DRB CASE ACTION LOG (SITE PLAN B.P.)

DRB Application No.: 06DRB-01632 (SBP)

Project # 1004927

Project Name UNIVERSITY HTS ADDITION

project title
Bricklight Courtyards
Lots 6-10, 17-21, Block 1, University Heights
Albuquerque, New Mexico
sheet title
Site Utility Plan

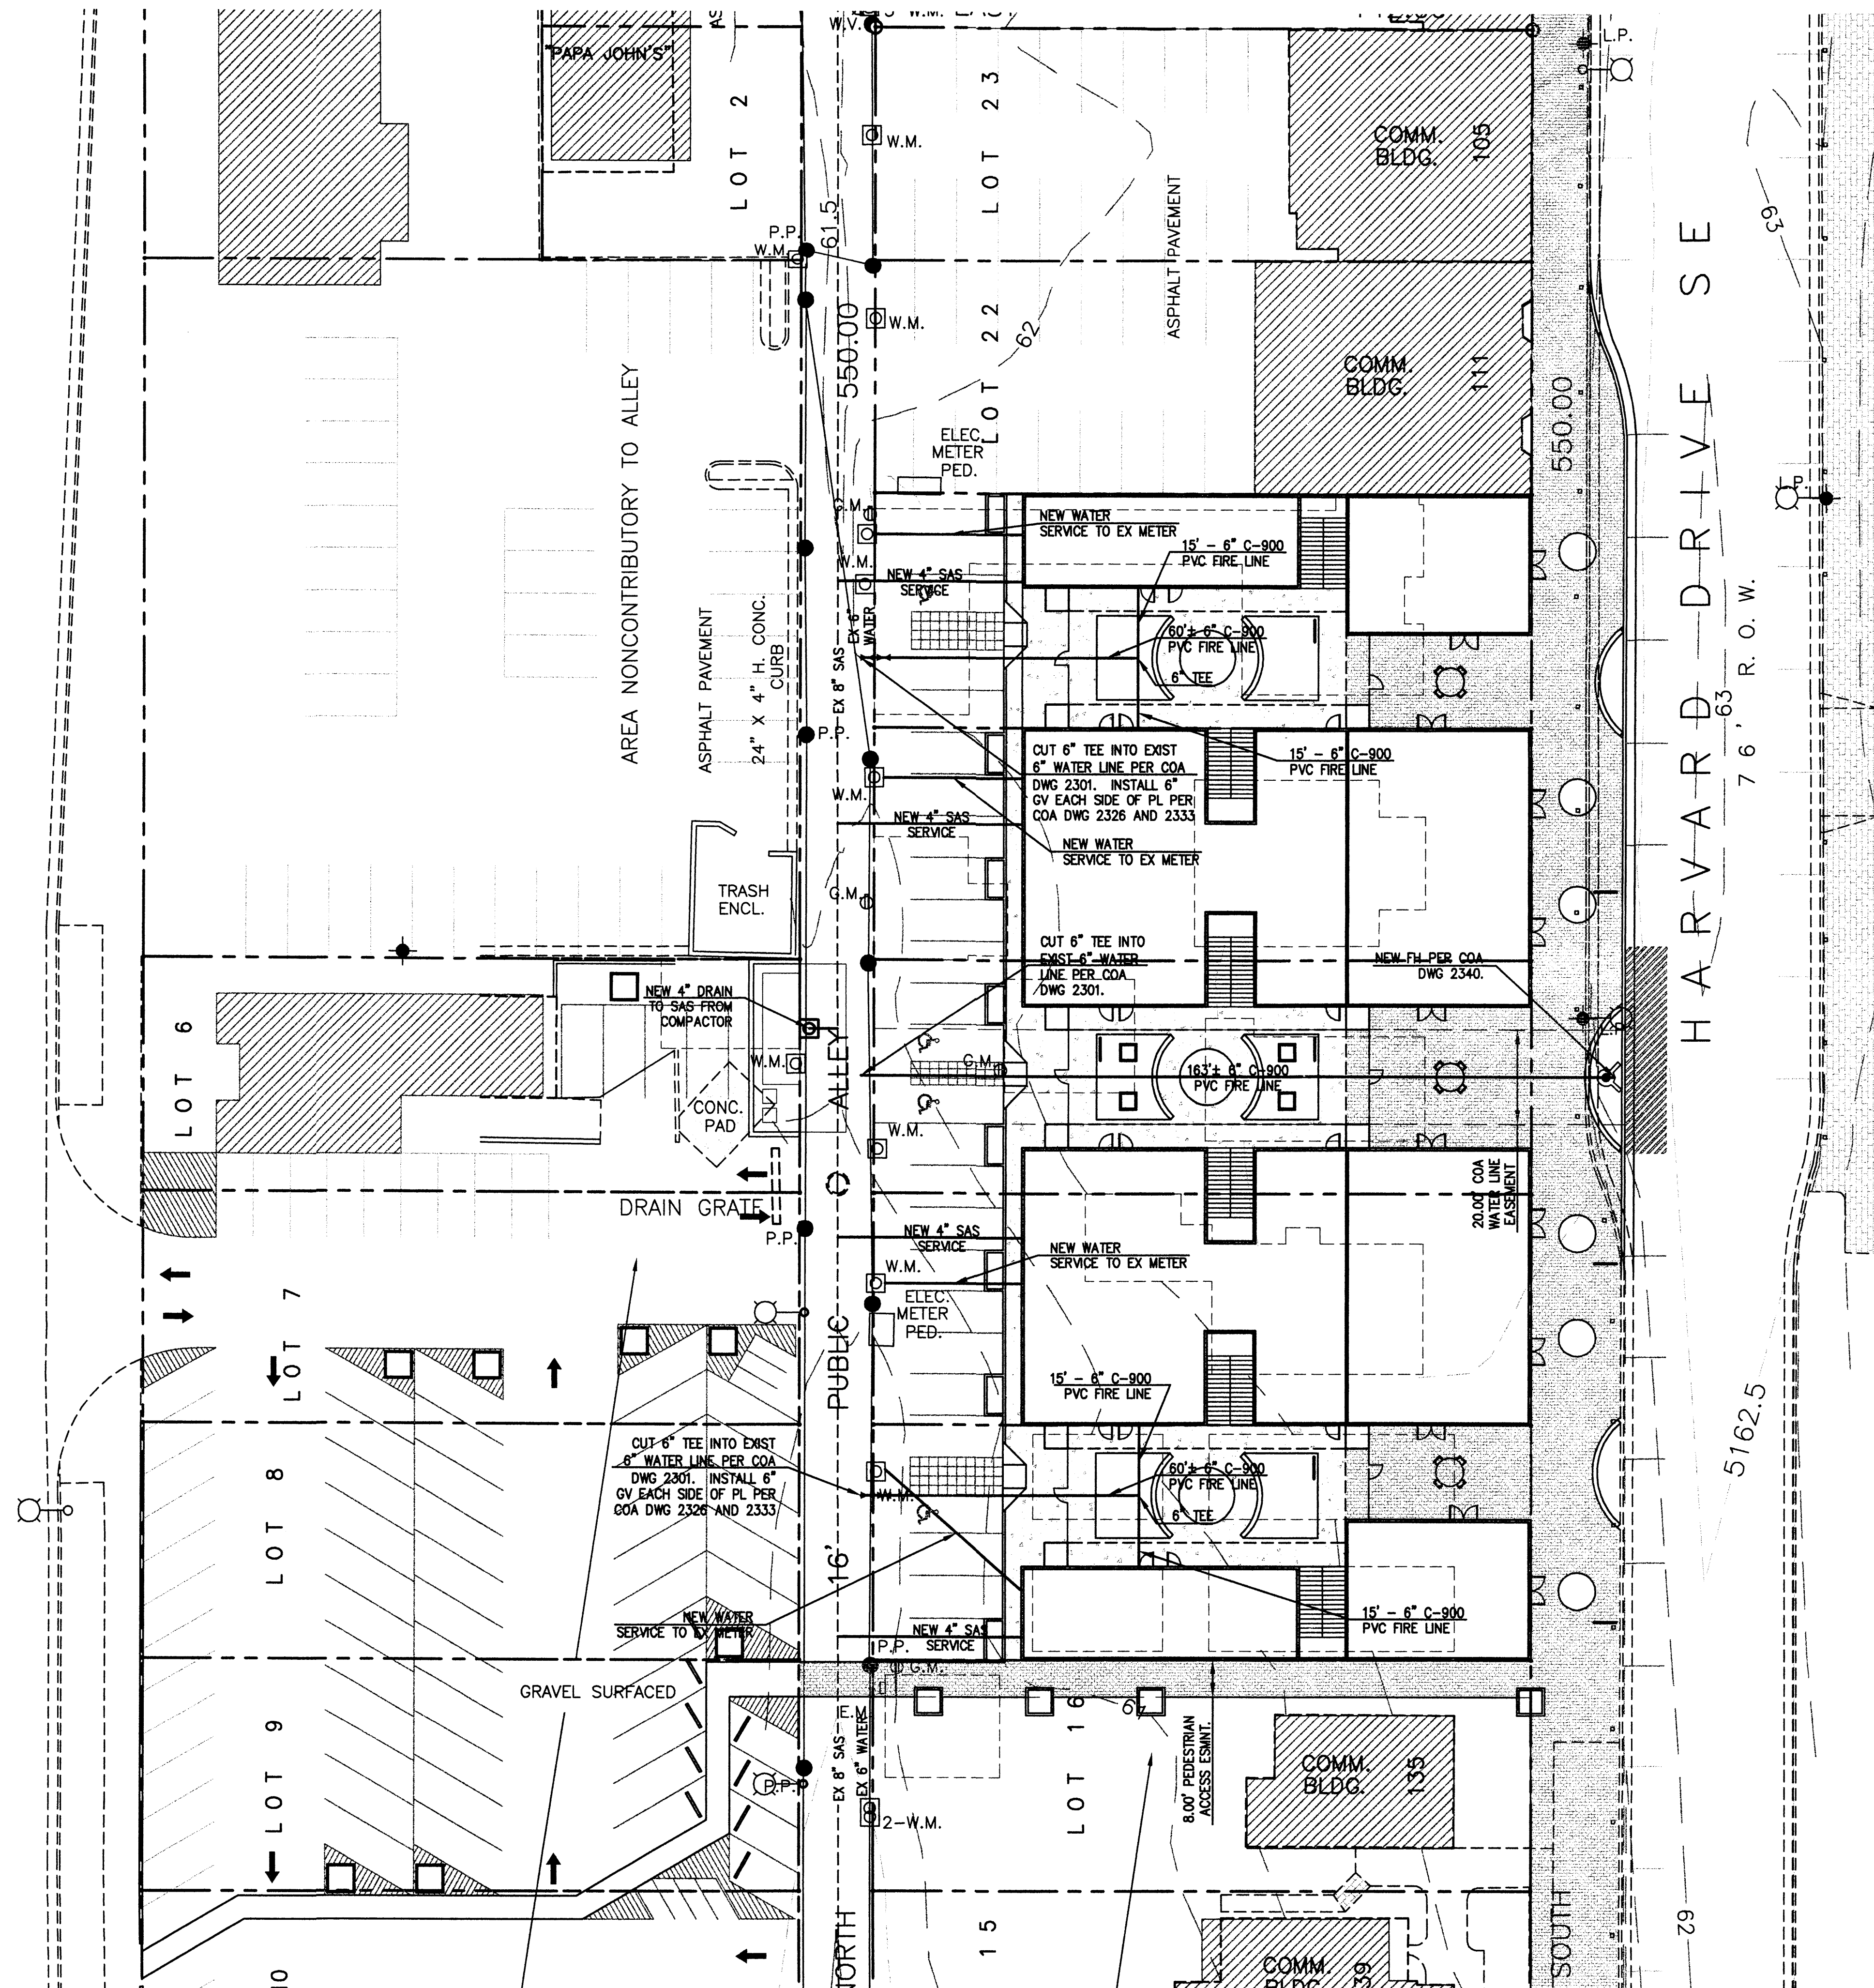
CITY ENGINEER / AMAFCA: S/A
 w/SAS esmt along alley (5')

MULLEN HELLER ARCHITECTURE agent(s) for HARVARD MALL PARTNERS request(s) the above action(s) for all or a portion of Lot(s) 6-10 & 16-21, Block(s) 1, **UNIVERSITY HEIGHTS ADDITION**, zoned SU-1 for UC & R3C, located on HARVARD DR SE between CENTRAL AVE SE and SILVER AVE SE containing approximately 2 acre(s). [REF: 06EPC-00777] [**Stephanie Shumsky, EPC Planner**] [*Def. 11/22/06, 1/24/07 & 2/7/07*] (K-15 & K-16) **WITH THE SIGNING OF THE INFRASTRUCTURE LIST DATED 5/09/07 THE SITE PLAN FOR BUILDING PERMIT WAS APPROVED WITH FINAL SIGN OFF DELEGATED TO CITY ENGINEER FOR SIA, ADDITIONAL SANITARY SEWER EASEMENTS ALONG THE ALLEY (5-FEET) AND PLANNING FOR STEPHANIE SHUMSKY'S INITIALS AND 3 COPIES.**

PLAT OF
 LOTS 16-A & 17-A, BLOCK 1
UNIVERSITY HEIGHTS
 ALBUQUERQUE, BERNALILLO COUNTY, NEW MEXICO
 SECTION 22, T. 10 N., R. 3 E., NMPM
 DECEMBER 2006

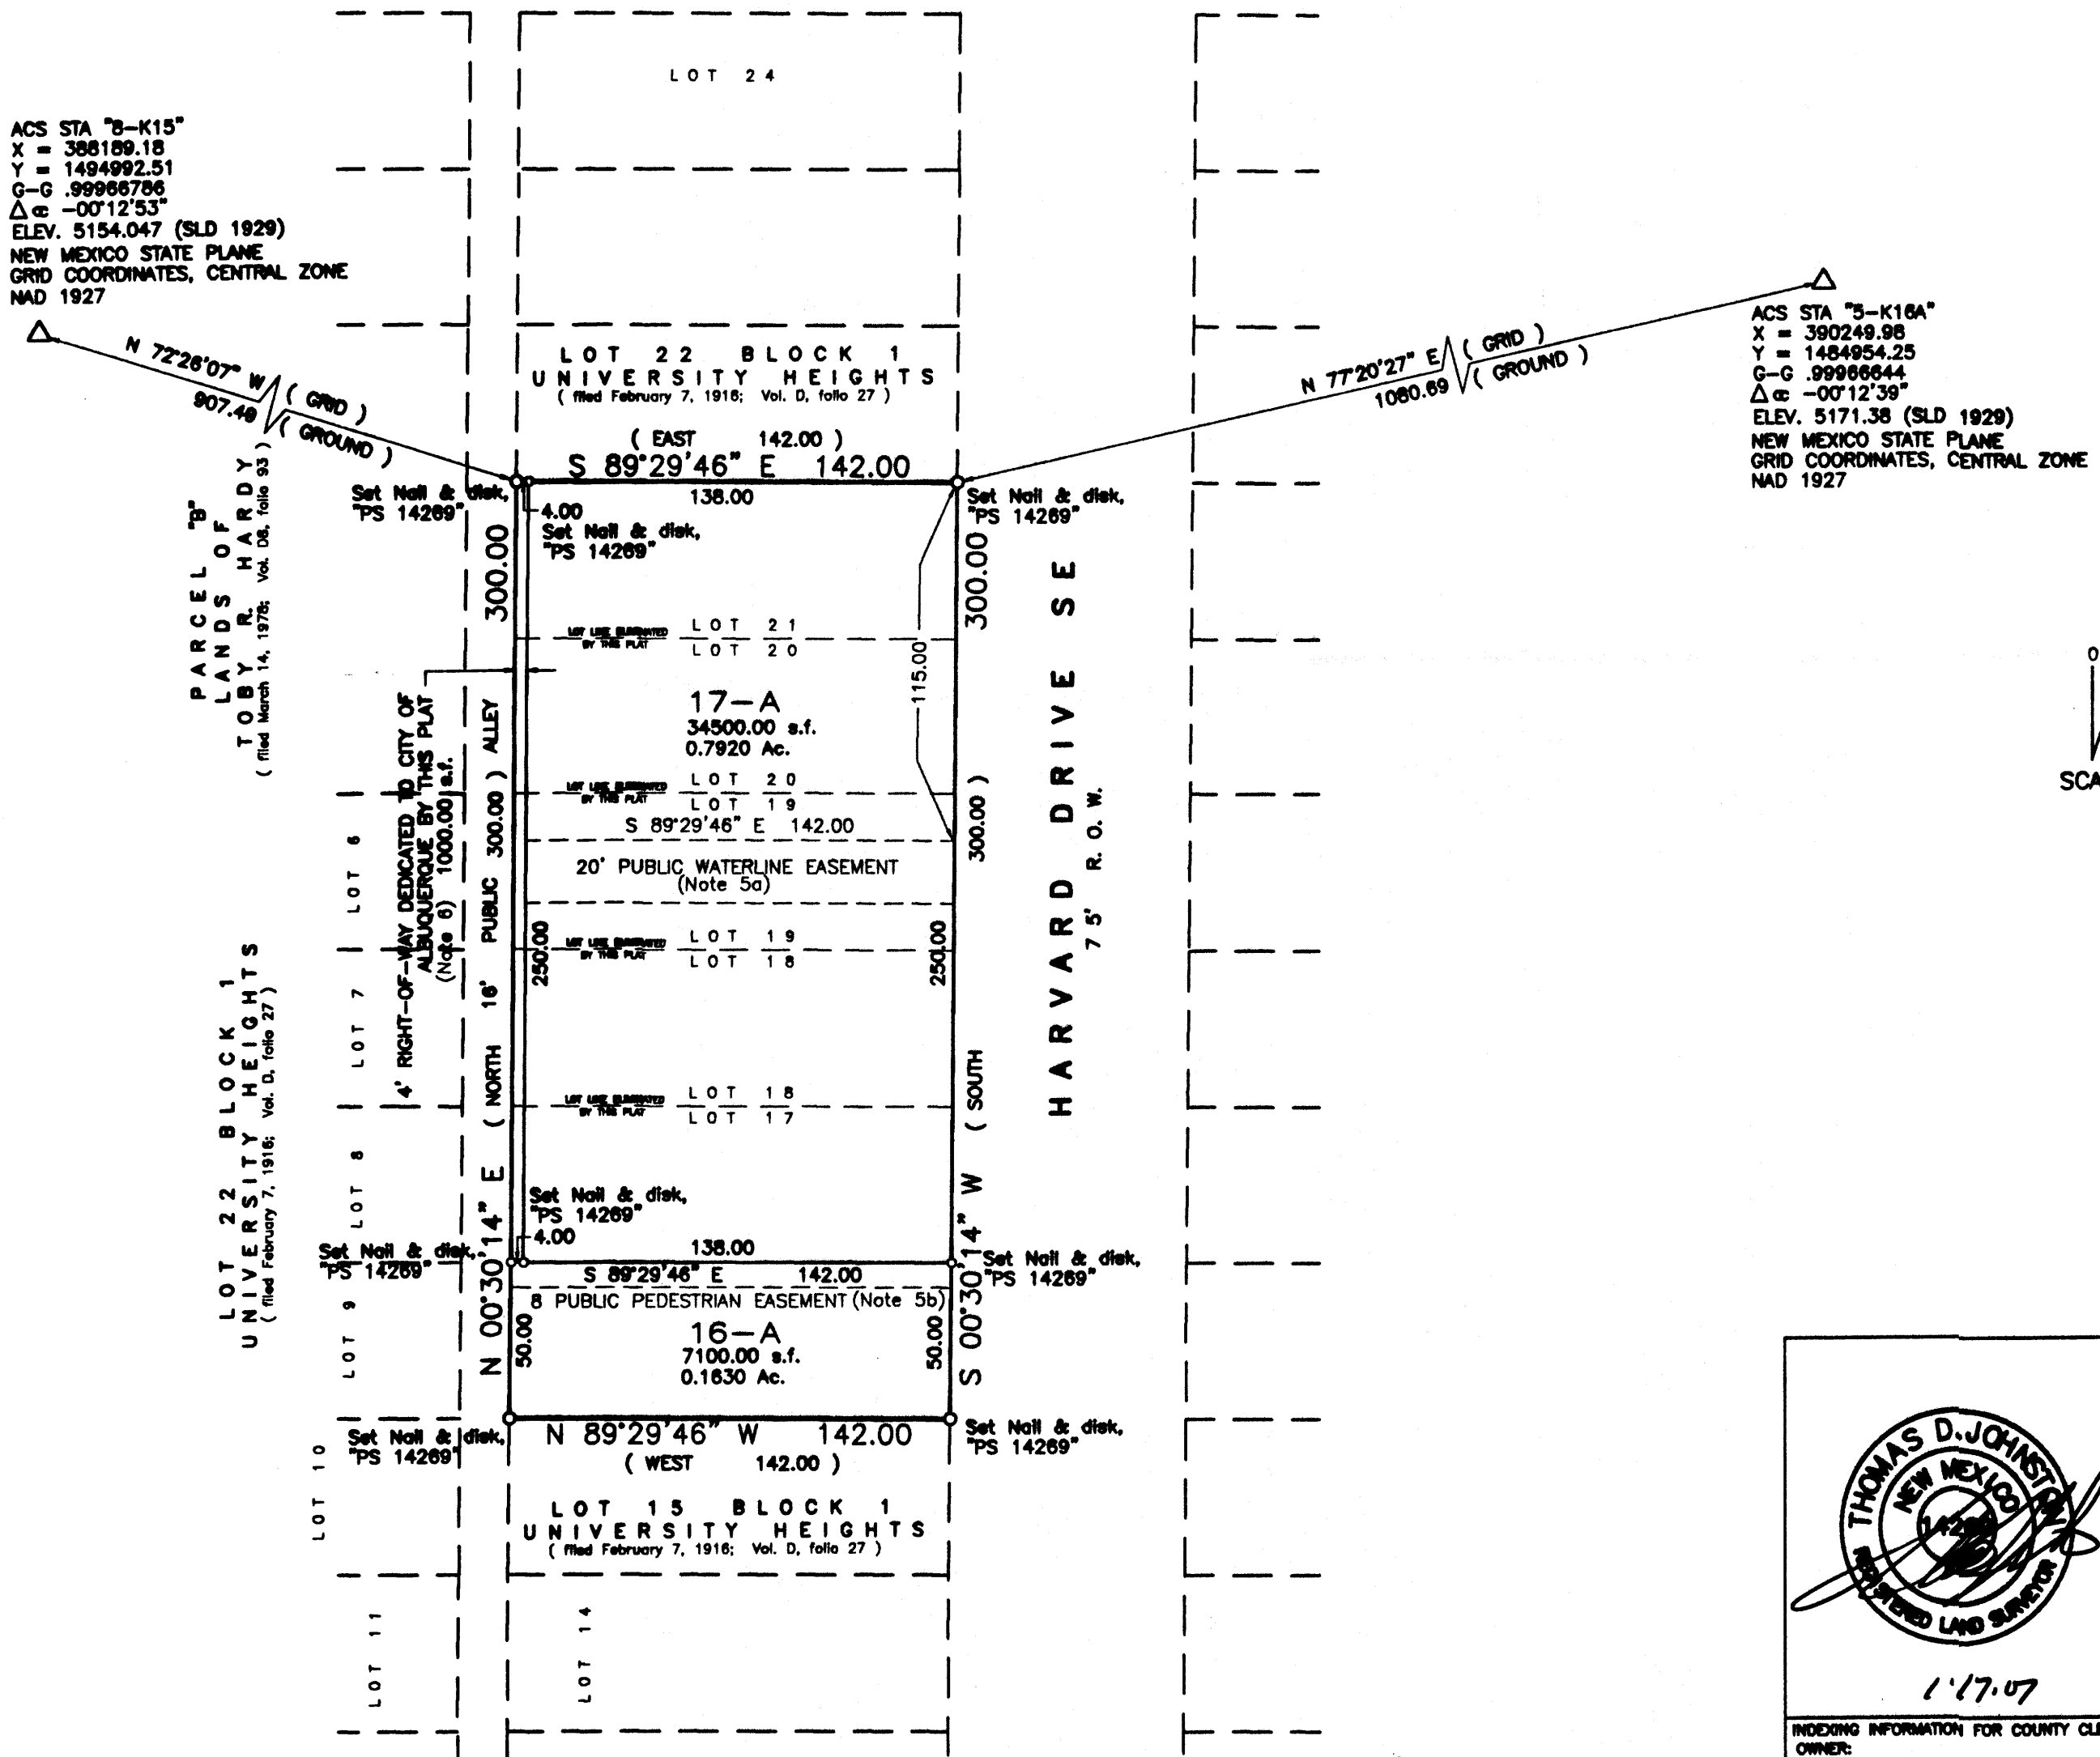
UTILITIES: Additional w/s easement.

WAYJOHN SURVEYING INC. agent(s) for HARVARD MALL PARTNERS request(s) the above action(s) for all or any portion of Lot(s) 16-21, Block(s) 1, **UNIVERSITY HEIGHTS ADDITION**, zoned SU-2 for UC & R3C, located on HARVARD DR SE between CENTRAL AVE SE and SILVER AVE SE containing approximately 1 acre(s). [REF: 06DRB01632] (K-15 & K-16) **THE PRELIMINARY AND FINAL PLAT WAS APPROVED WITH FINAL SIGN OFF DELEGATED TO UTILITIES DEVELOPMENT FOR ADDITIONAL WATER AND SEWER EASEMENT AND TO PLANNING FOR APS LANGUAGE, AGIS DXF FILE AND TO RECORD.**
